**COMMUNITY SERVICES DEPARTMENT**

January 4, 2022

**Subject: Grandview Reserve Filing No. 1 PUD Preliminary Plan, Review #2 – (PUDSP-21-010)**

DETAILED LANDSCAPE
PLAN

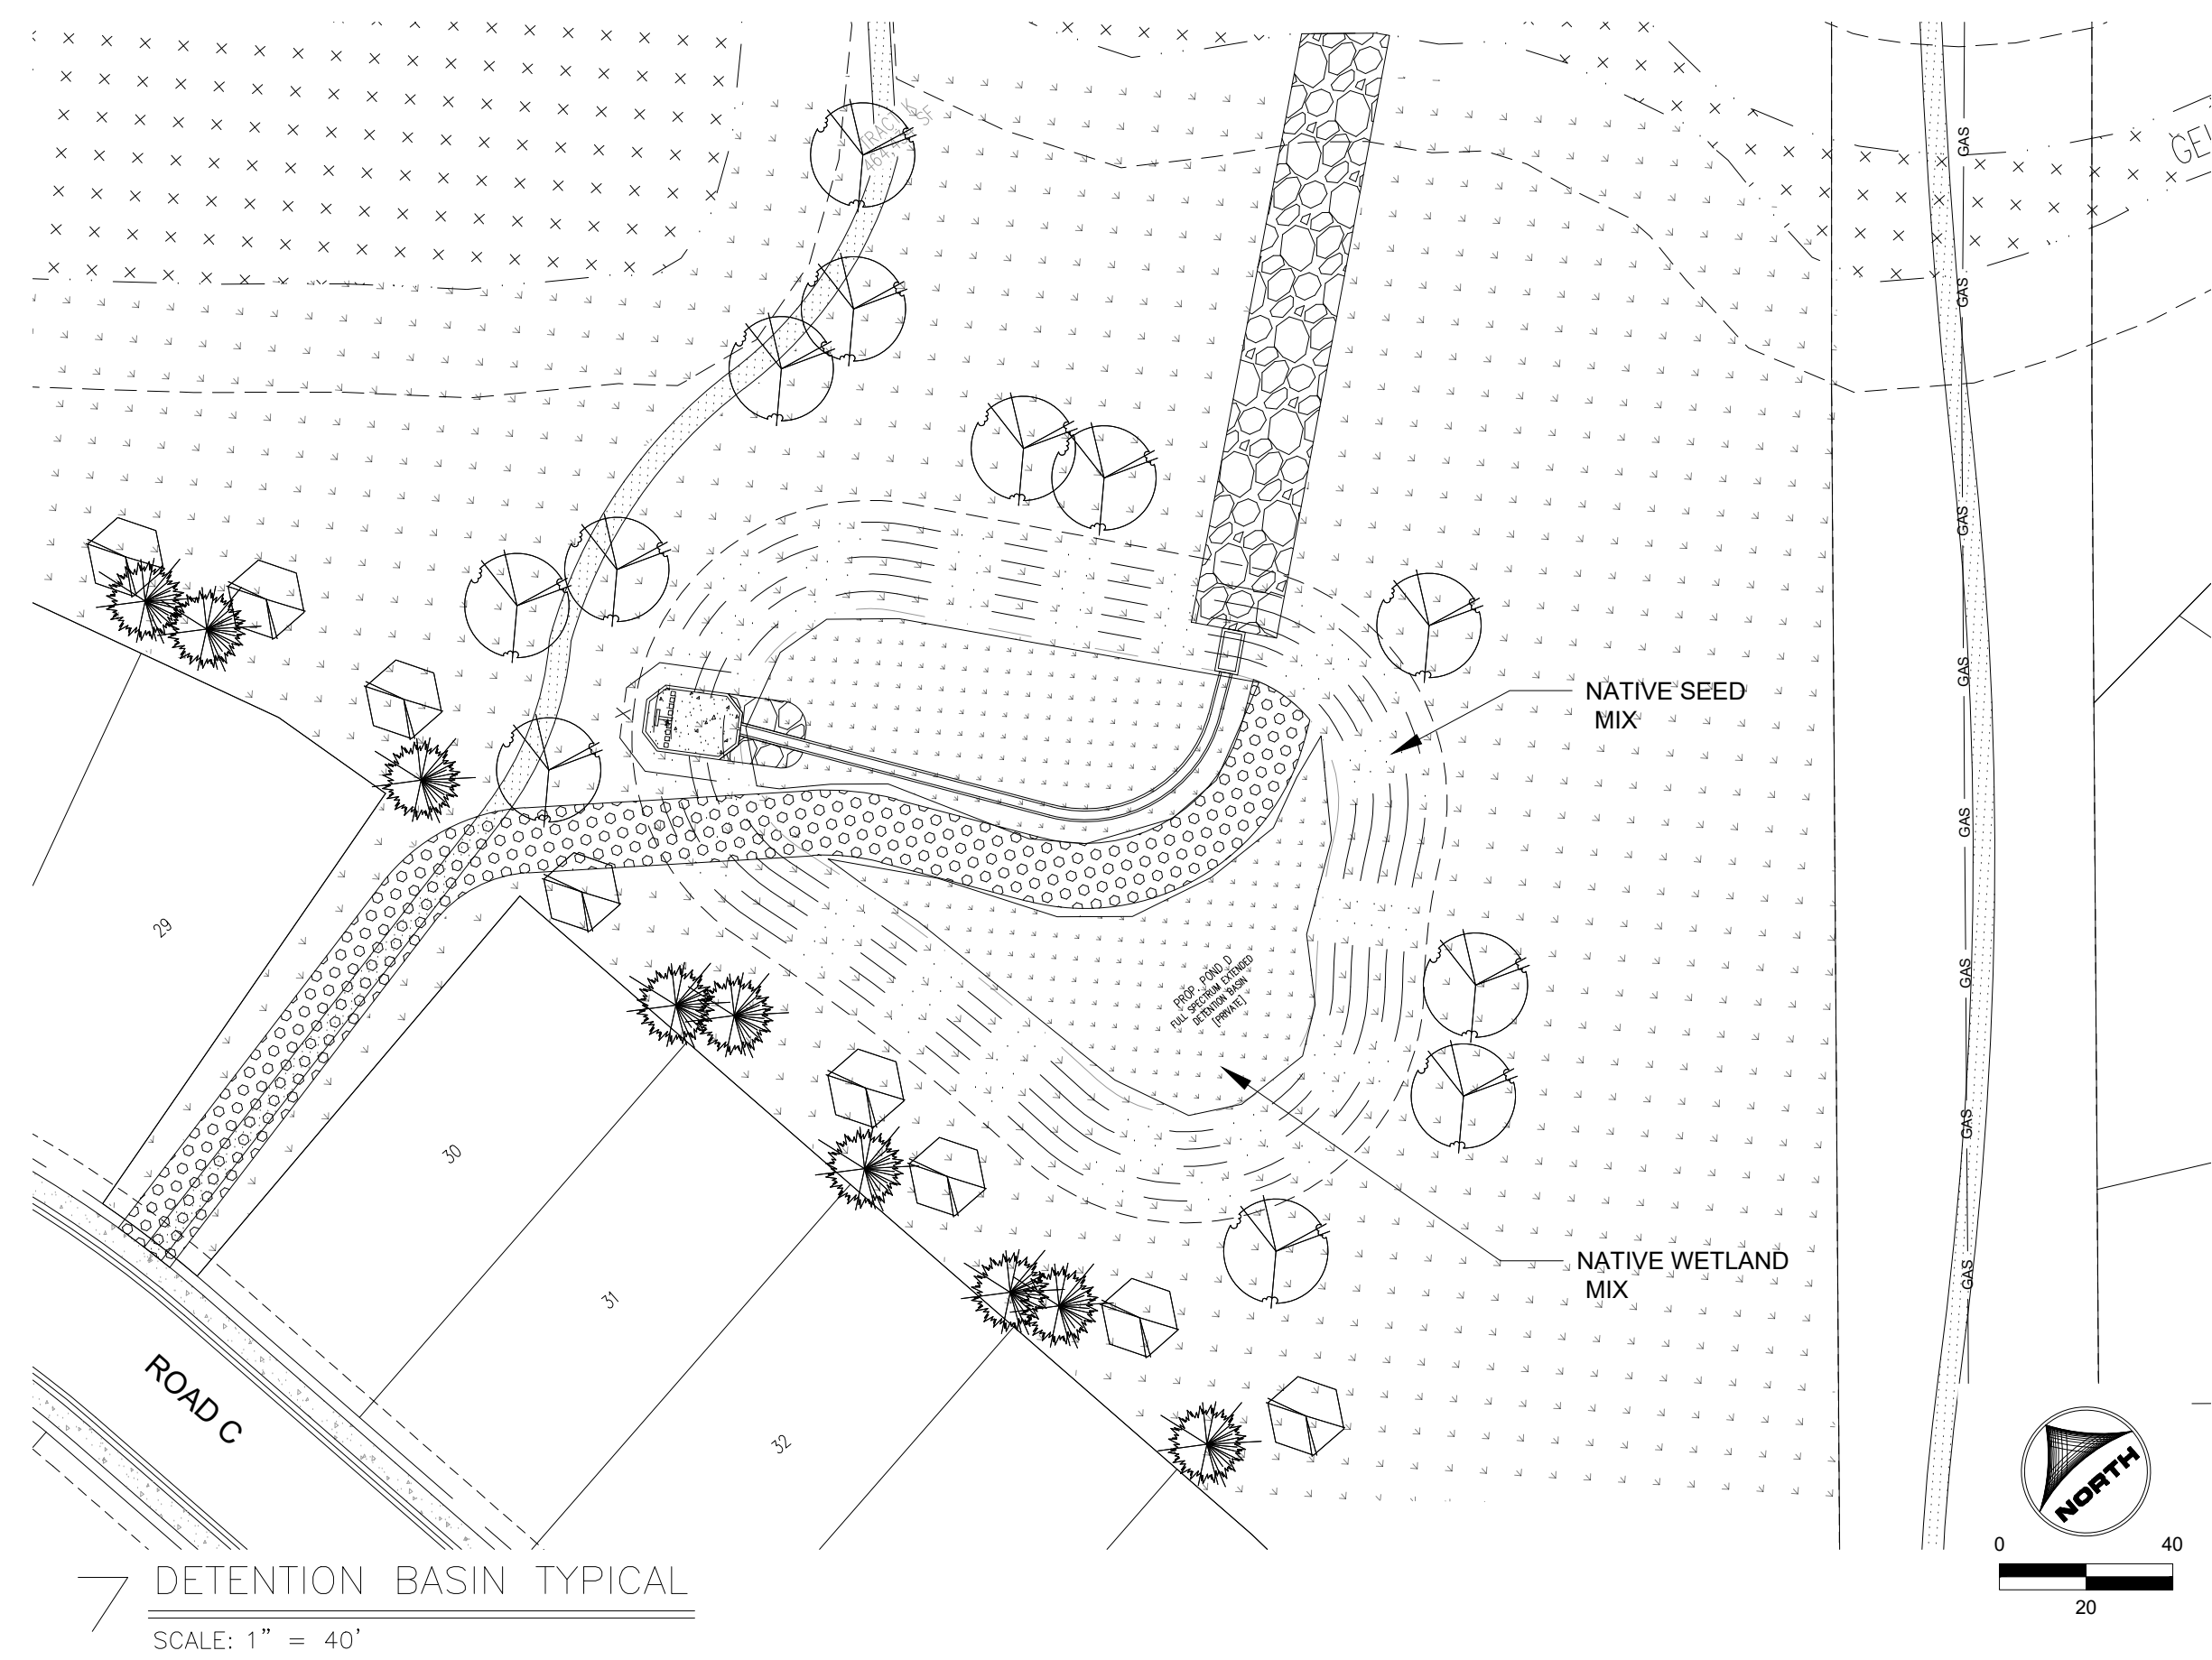
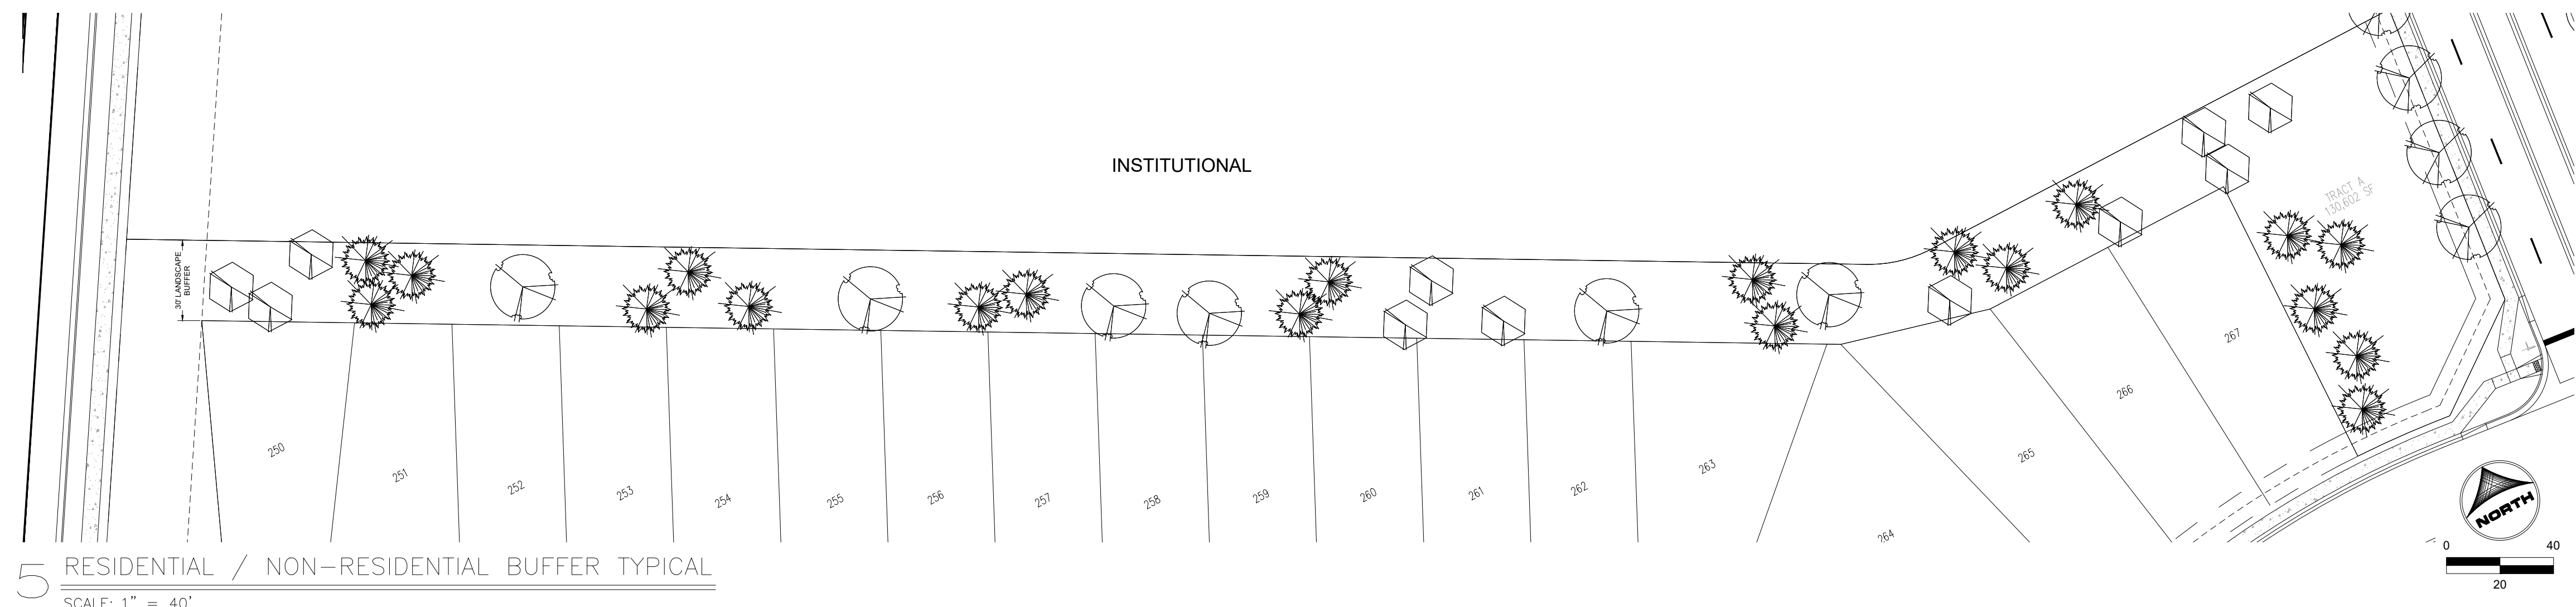
*Moreover, staff recommends that the applicant submit detailed site plans for the proposed Amenity Center, as the currently proposed neighborhood pocket park does not include multi-generational recreational amenities such as a playground, multi-use turf field, or seating and picnic areas. The submitted Landscape Plans only show landscaping and a connecting pathway within the proposed pocket park.*
